From: Brenda Larsen
Sent: Wednesday, January 30, 2013 9:22 AM
To: Jeff Watson
Subject: RE: BL-12-00033 Tugwell

Re: Tugwell (BL-12-00033)

After conducting a review of the above named project, I have the following comments:

Tugwell Property  
 2400 Umptanum Road  
 509-962-2501

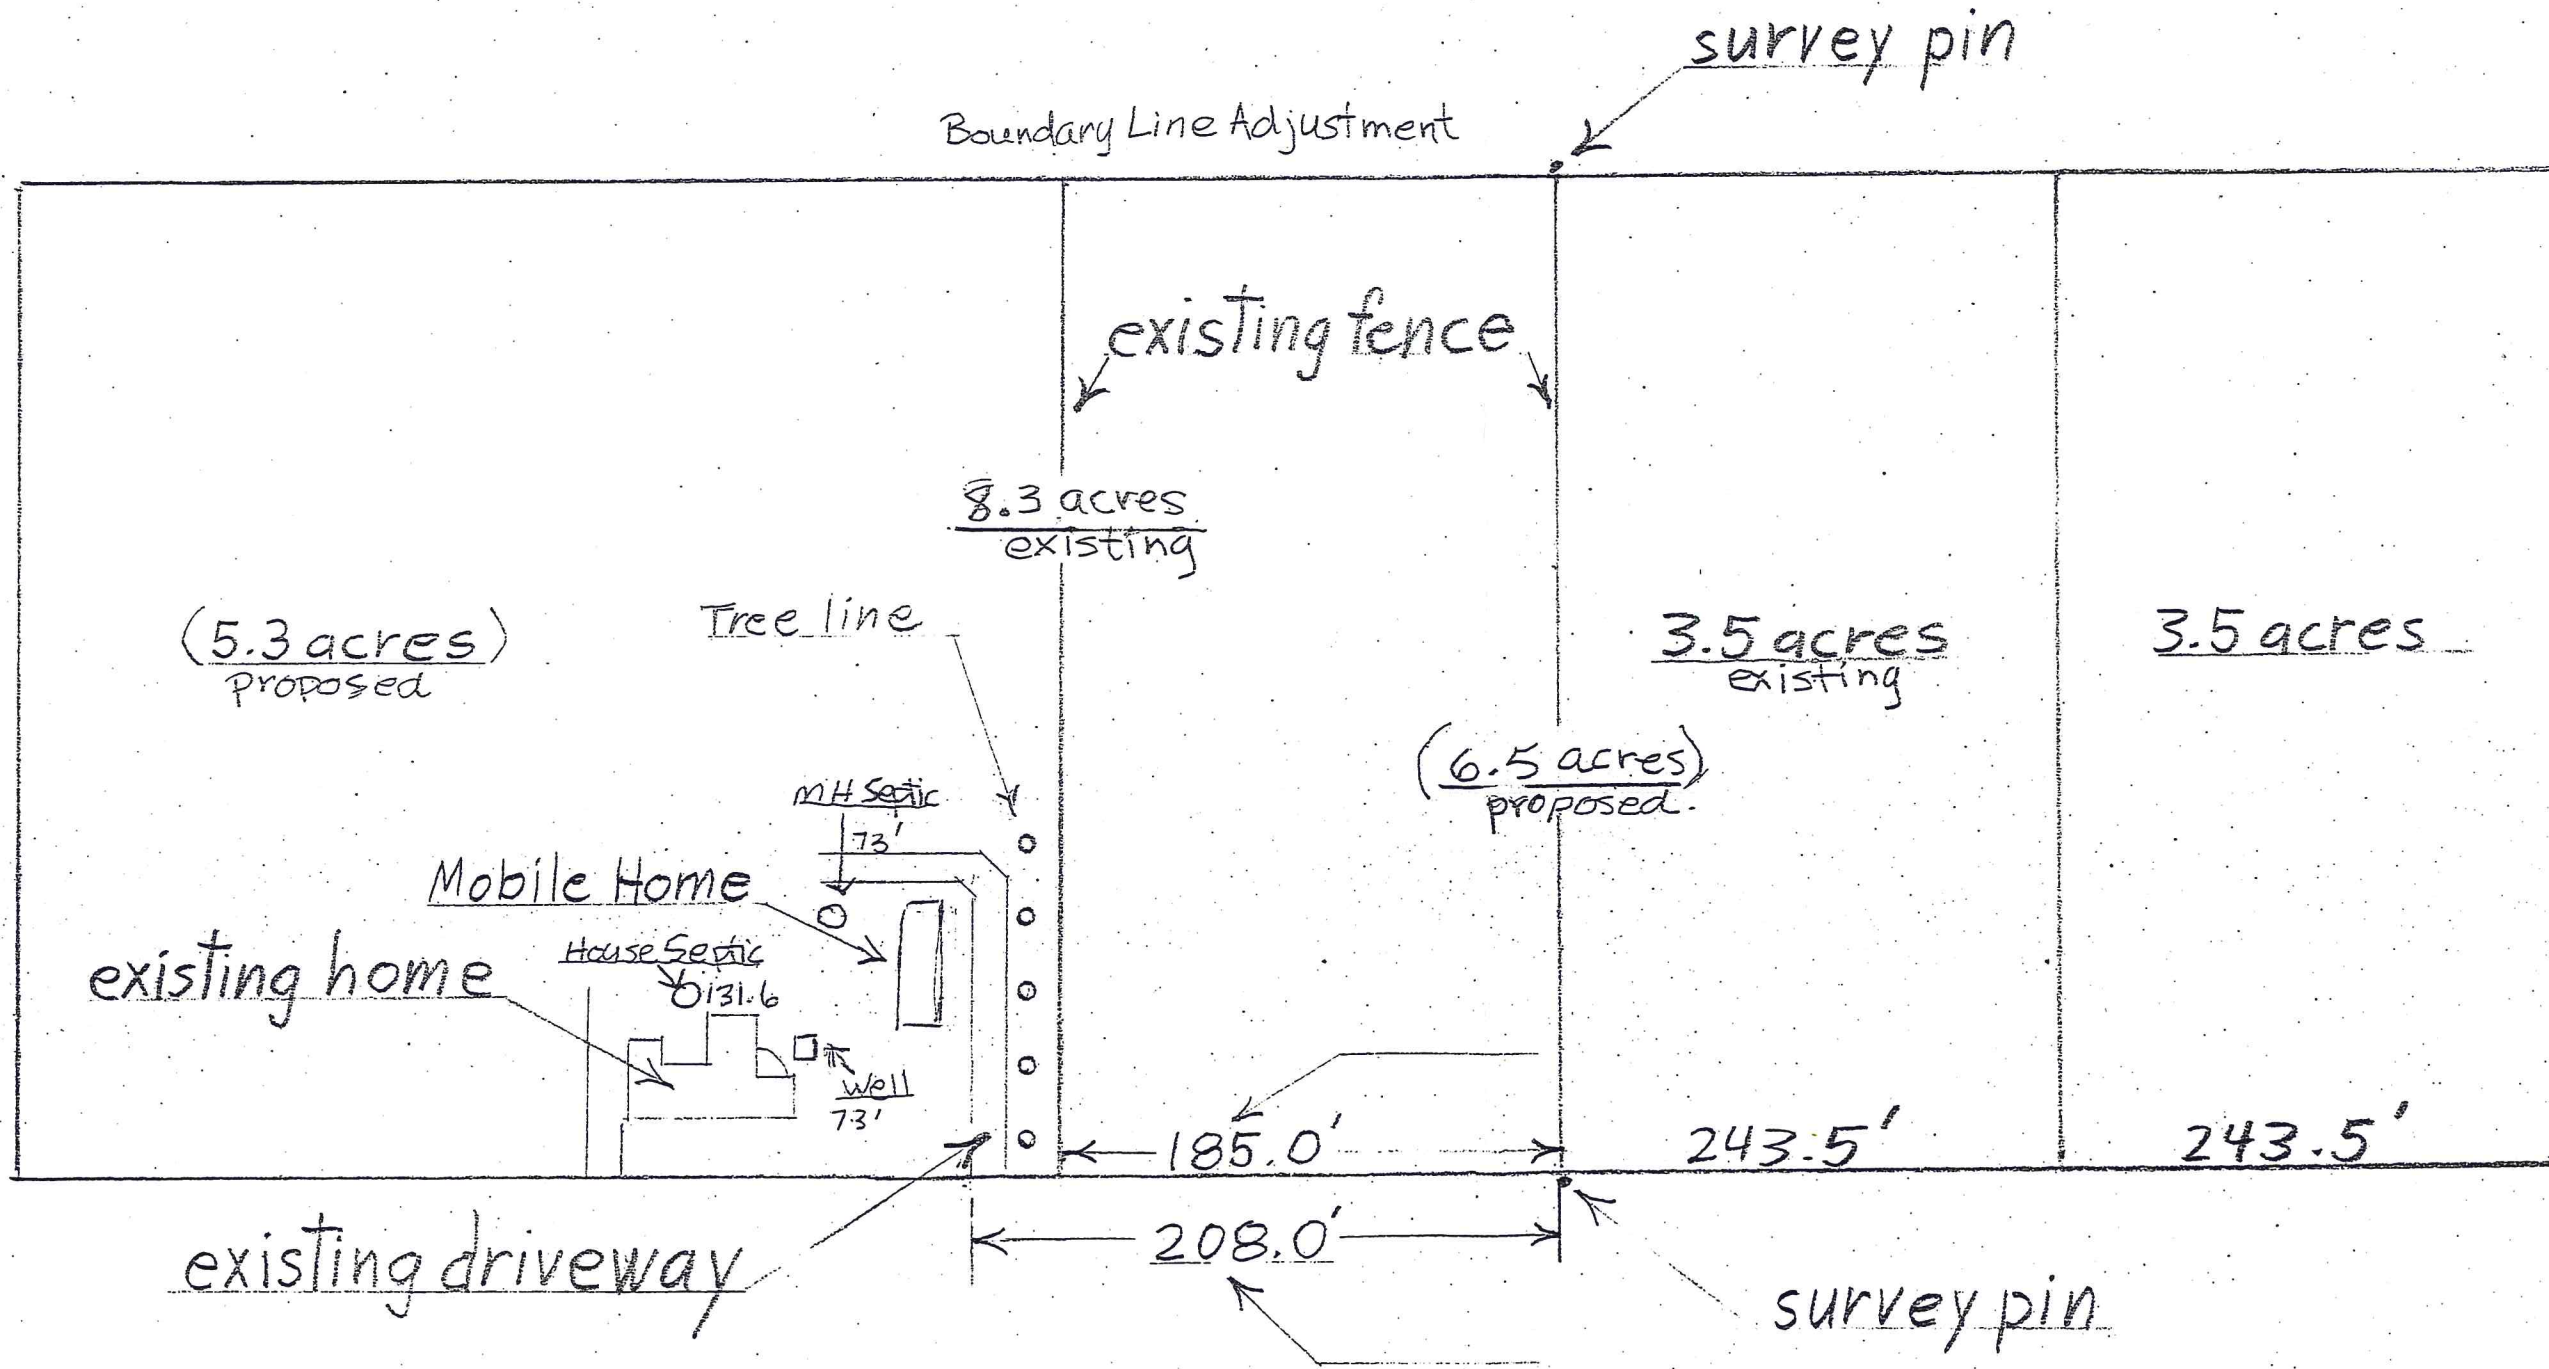
- Any new roads that are created are to comply with Kittitas County Road Standards and the International Fire Code.
- Ensure that boundary line adjustments do not infringe upon existing structures, to include propane tanks, etc.
- All future development must comply with the International Fire Code.
